Monday, 16 December 2013

**RE: Submission of the Sydney Cricket and Sports Ground Trust to the  
Public Exhibition of the CBD and South East Light Rail Project (SSI-6042)**

Figure 4-33: Moore Park Construction Haulage Route

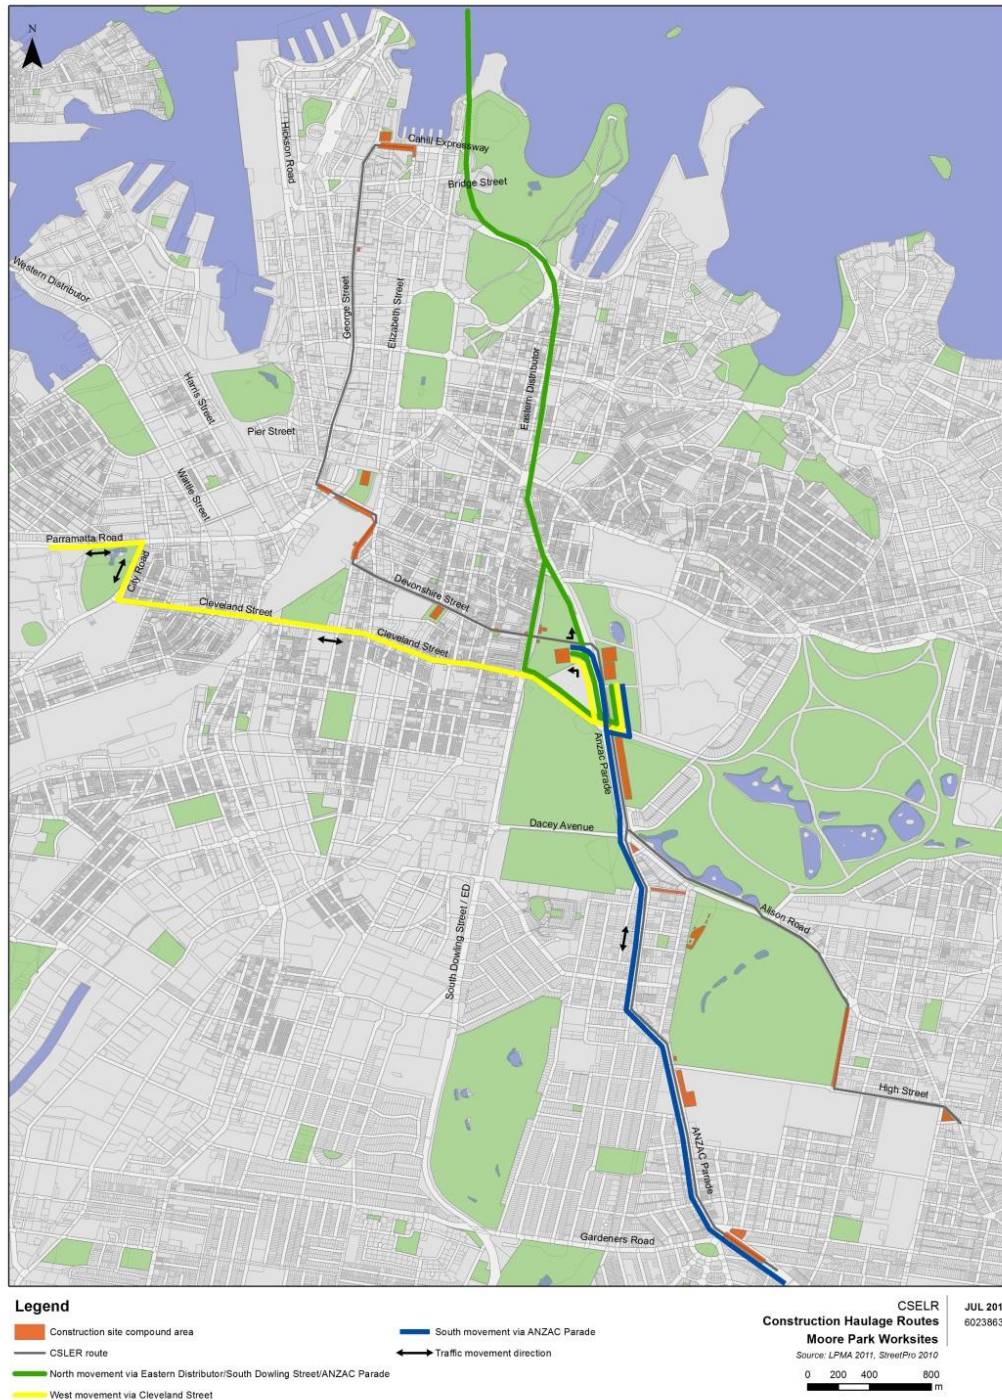
The Trust would seek that construction is staged to minimise significant disruption to major events in the Precinct, in particular during the Cricket World Cup in February and March 2015. Further, specific works, such as the installation of tracks across Lang Road and the existing bus loop, should not be done during sporting events in the Precinct which require high-frequency and volume access across these places. It is noted that, in future operating conditions, this intersection will operate less efficiently than in current conditions (EIS Technical Paper 2, p. 159). The Trust seeks clarification that this analysis has taken into account the larger traffic flows which occur before and after major events in the Precinct. A calendar of upcoming events in the Precinct is attached to this submission.

Figure 4-34: Lang Road Closure

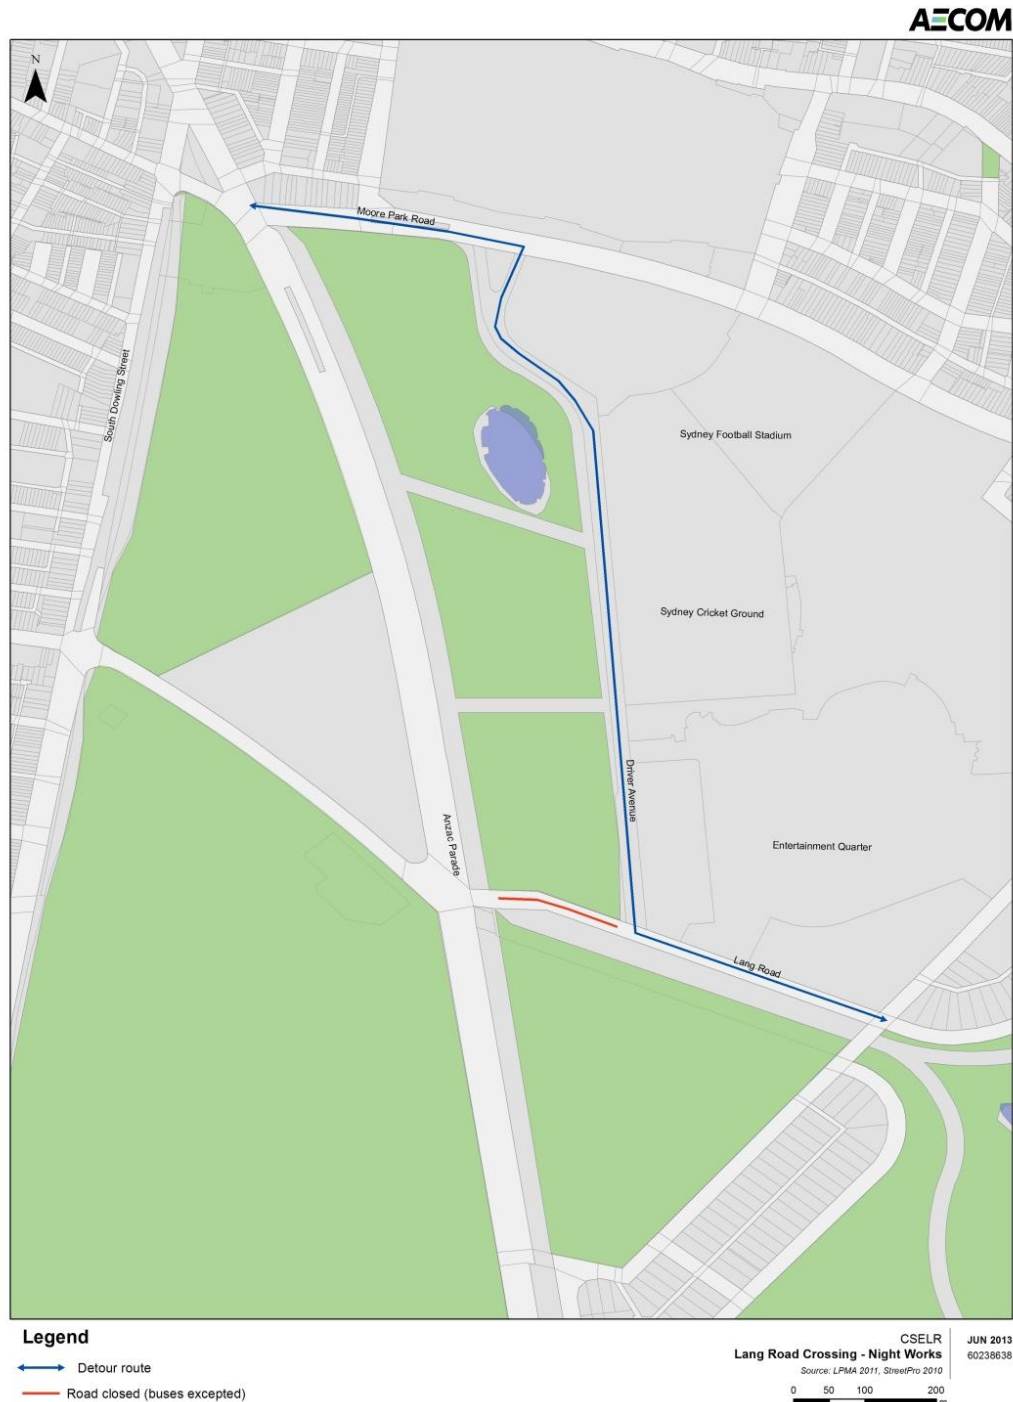
- The Trust does not support the proposed construction site office and compound north of the tunnel portal in Moore Park East. This location is the site of a recently constructed elite training field, and such a site office would both force the relocation of professional sporting teams and undermine a significant investment by the Trust. It is essential that access to the elite training fields are retained throughout the construction process.
- The construction management program should have regard to the importance of Moore Park East as a car parking area, the timing of major international events such as the 2015 Cricket World Cup, and the operation of important intersections, in particular the corner of Anzac Parade and Lang Road.

Figure 7-12: Moore Park Precinct Access Plan

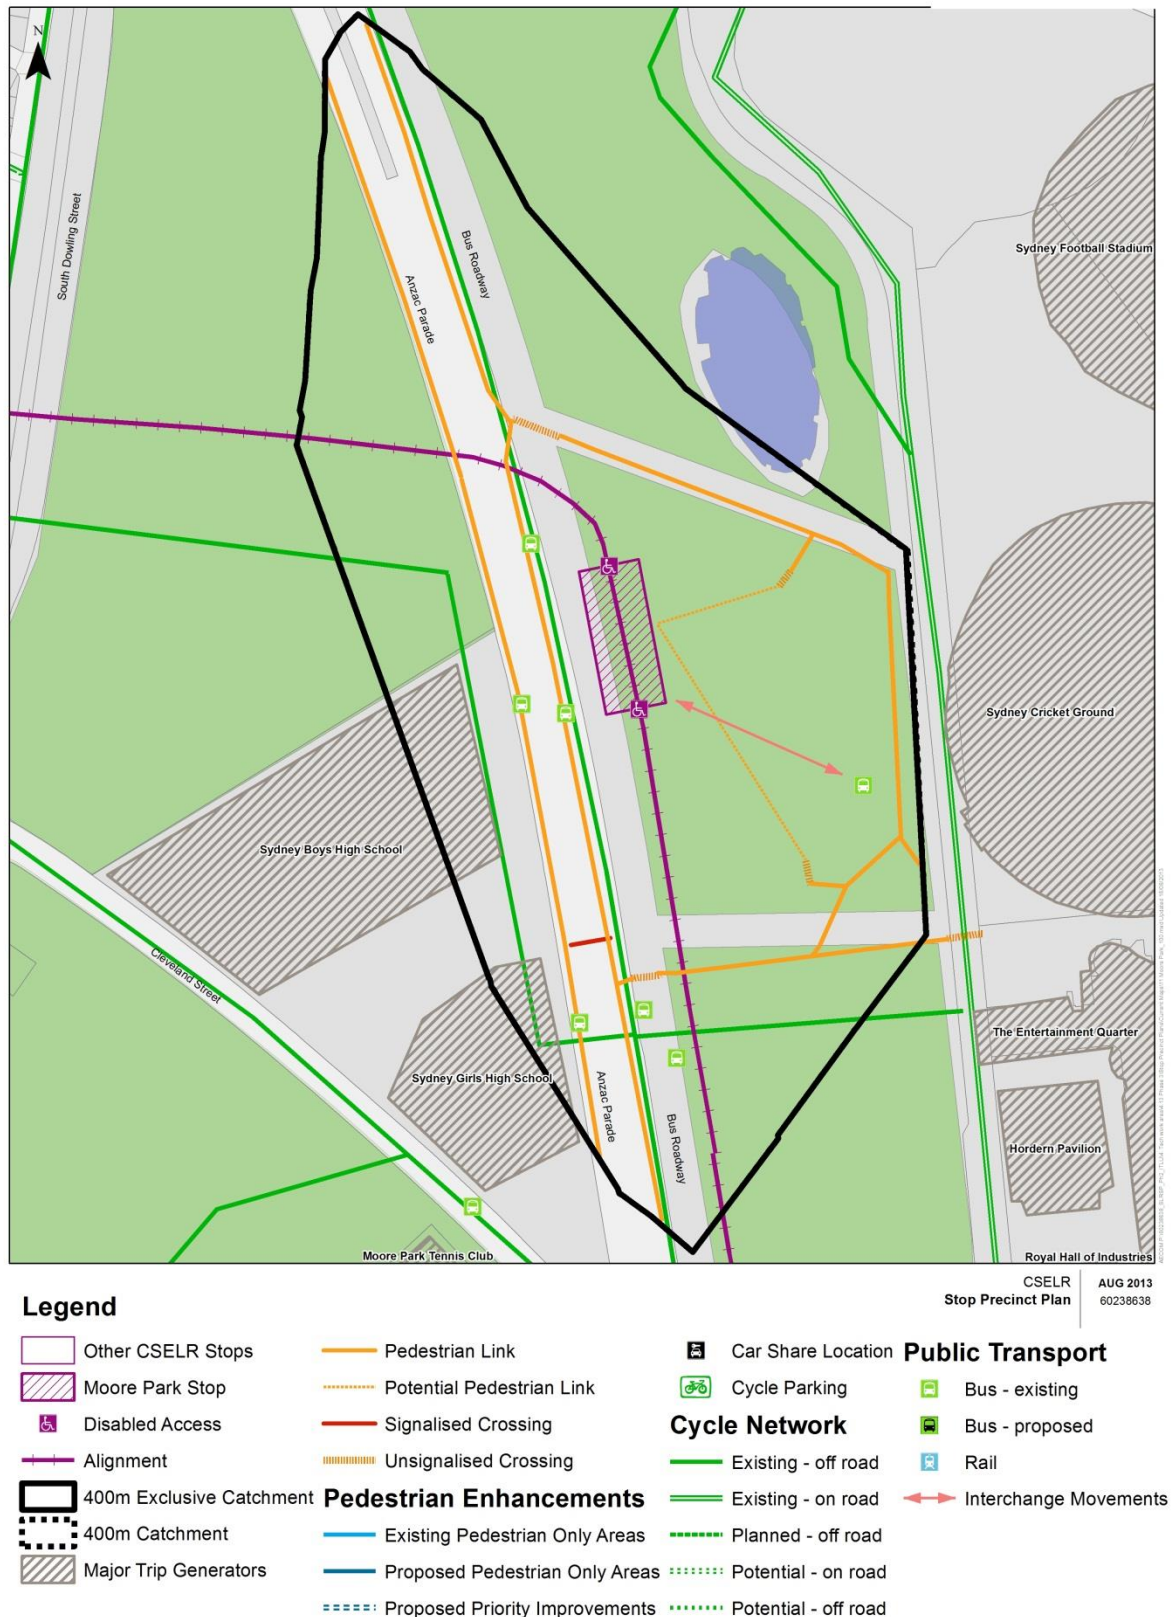
The location and design of the Moore Park Station must not be considered in isolation from its connections with the broader Precinct. For the CSELR to positively contribute to the Precinct's access to an integrated transport, it is necessary to consider important changes to the function of existing roadways and improvements to the Precinct's public domain and pedestrian layout to support active use. The EIS includes an Integrated Event Transport Plan (p. 9-34) for the Precinct which demonstrates useful initiatives to comprehensively review access to Moore Park, however there is no timeframe or commitment to implement it. Key aspects of the Plan include:

- Removal of the existing bus loop and extension of Tramway Oval to supplement land lost to the CSELR to the west;
- Establishment of a new bus interchange north of Gregory Avenue;
- Construction of a pedestrian footbridge across Anzac Parade connecting Moore Park East and Moore Park West;
- Additional car parking beneath the existing car park between Moore Park Road and Driver Avenue.

The Trust supports the implementation of the Integrated Event Transport Plan, subject to further consultation and refinement. In particular, the Trust seeks clarification on planning for the relocated bus loop, given that it is identified as being 'proposed' without being identified as part of the works for which approval is sought as part of the application, and that it would have a significant impact on existing operations of the Trust.
